**Re: Leisure Interiors, 47F Broad Street, Banbury OX16 5BT ("the Site")  
Planning Objection - 20/02087/O56**

DRAWING:
BLOCK PLAN

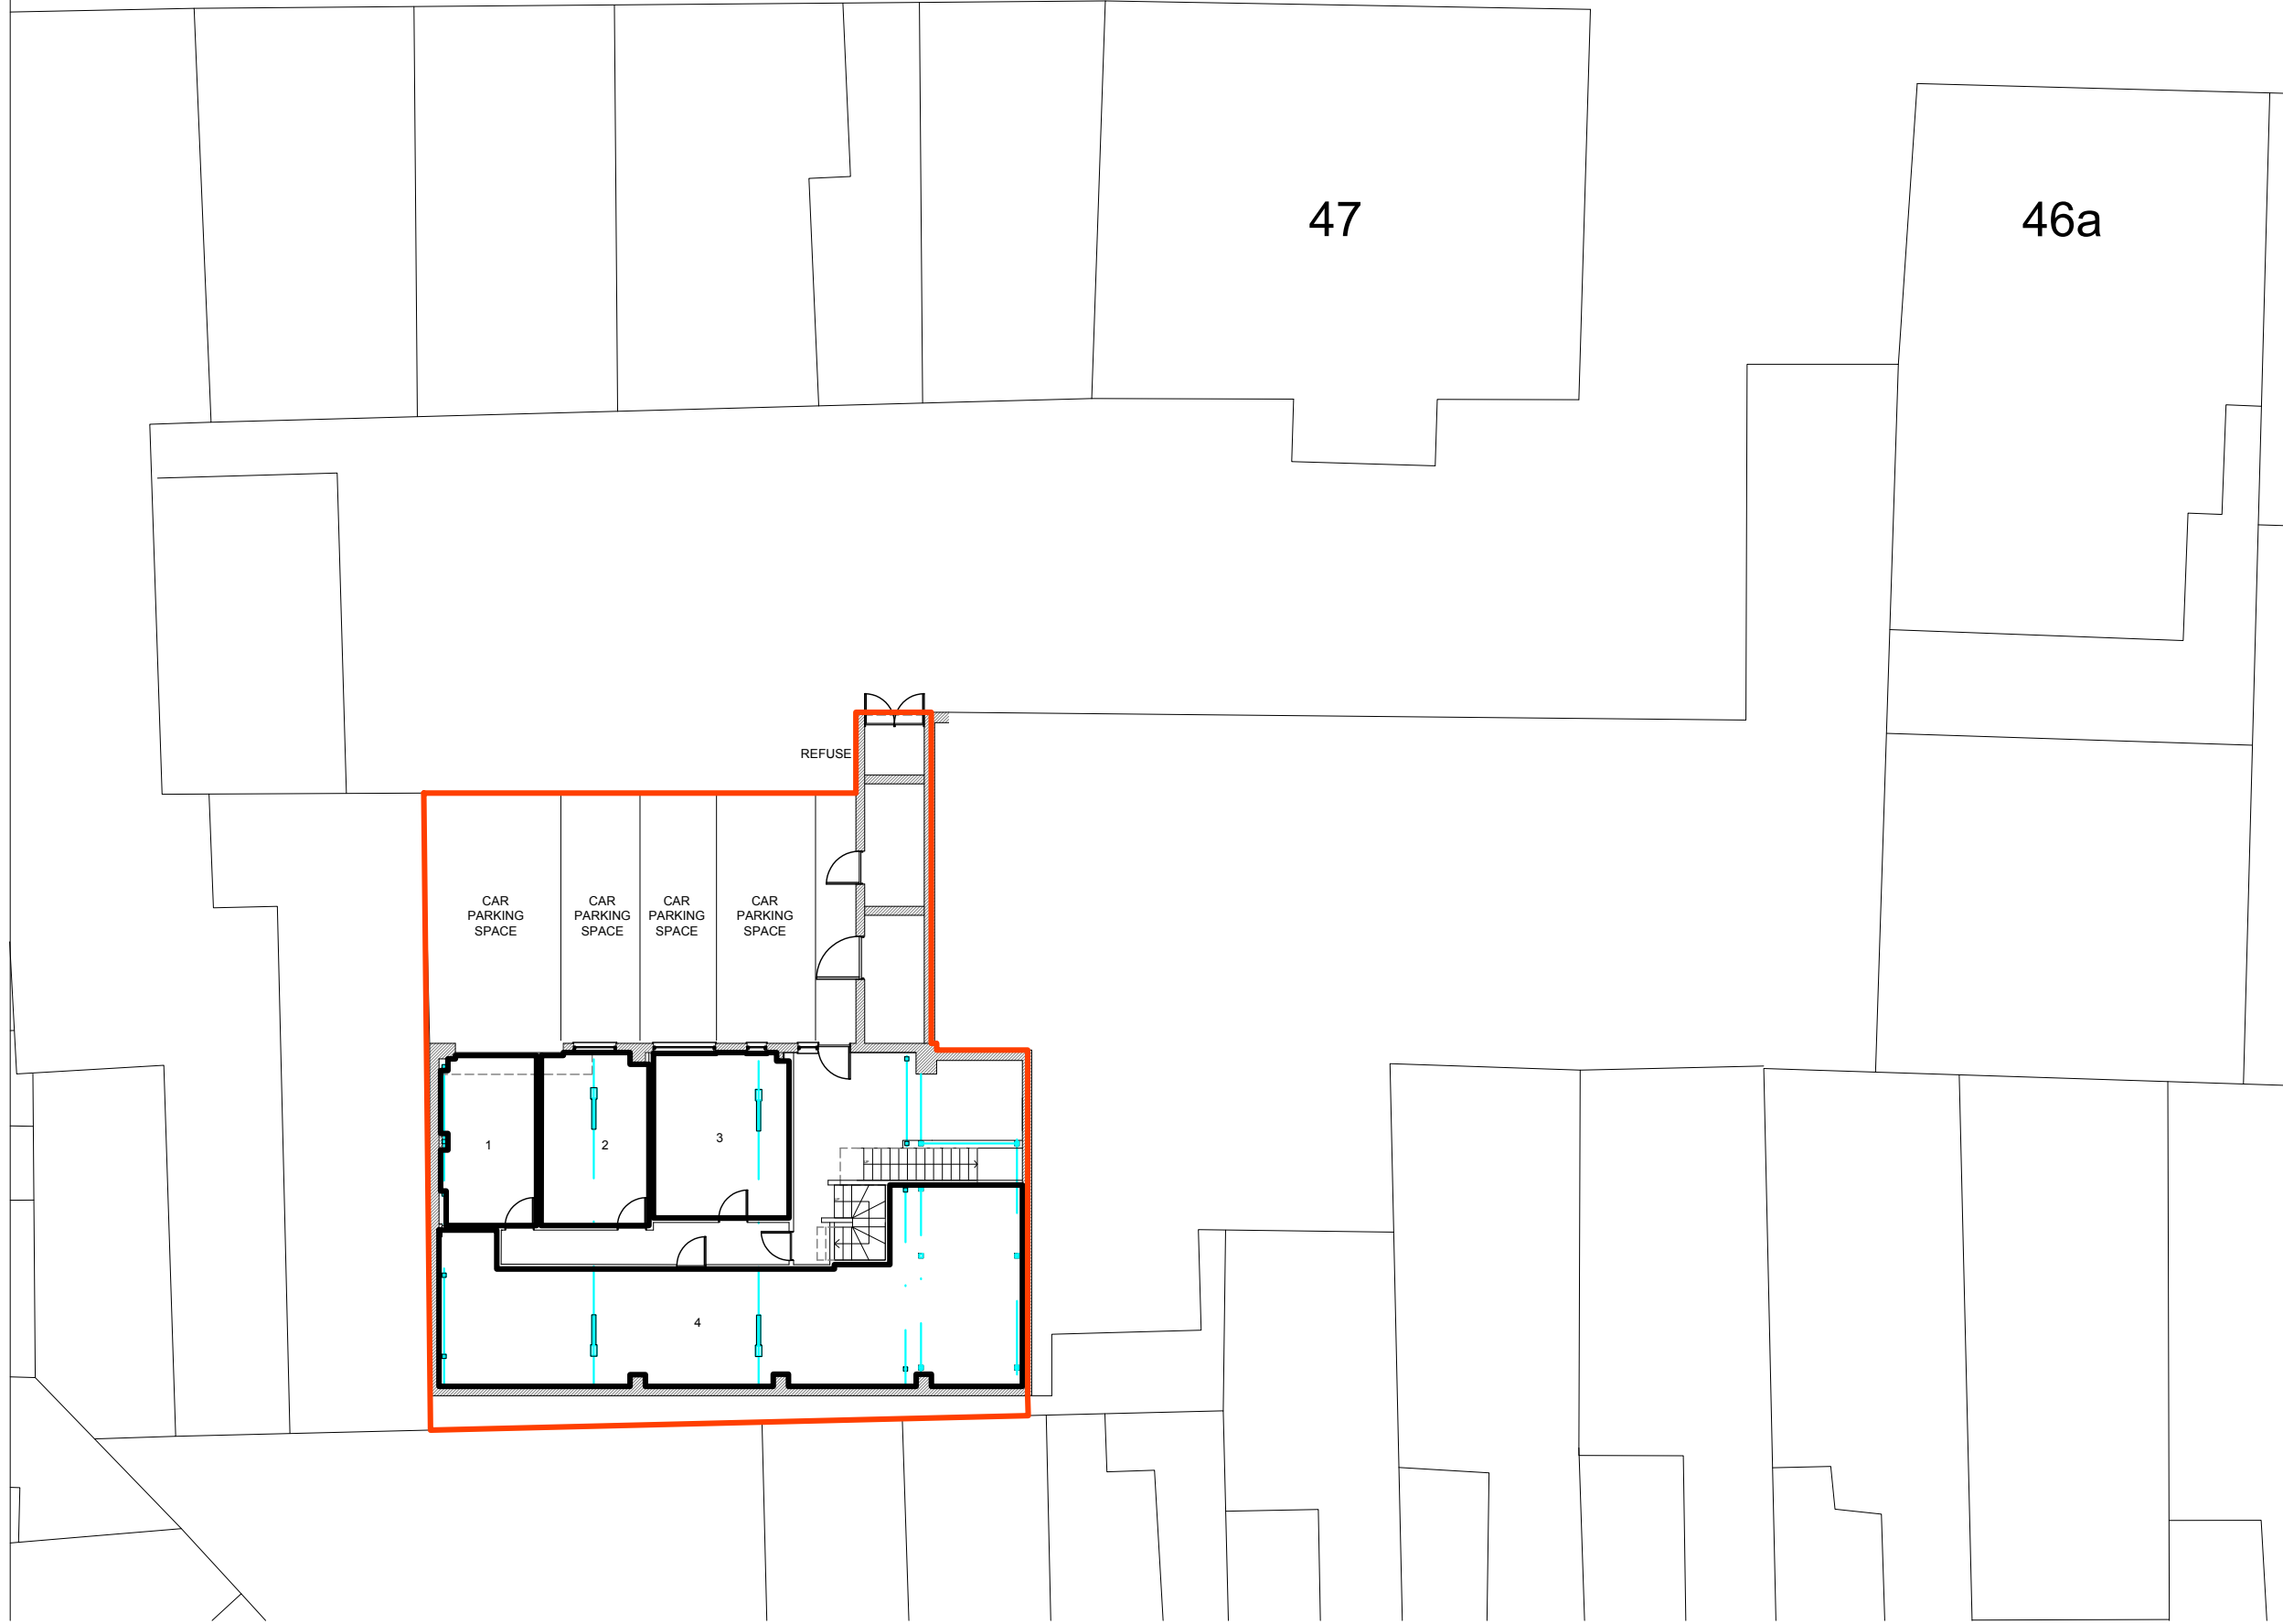
Firstly, as you will see from the proposed block plan, the only access to and from the Site is through a narrow entrance and corridor to the east abutting Broad Street.

The development of 18 new residential units would cause an increase in movement of pedestrians and cars through this narrow corridor, resulting in disruption to the local business that use the service yard at the rear facing the Site and would ultimately not be feasible.

Following on from the above, DRK Planning's covering letter states their will be "sufficient car parking space for 18 flats", however the block plans shows only 4 parking spaces, i.e 0.22 spaces per unit.
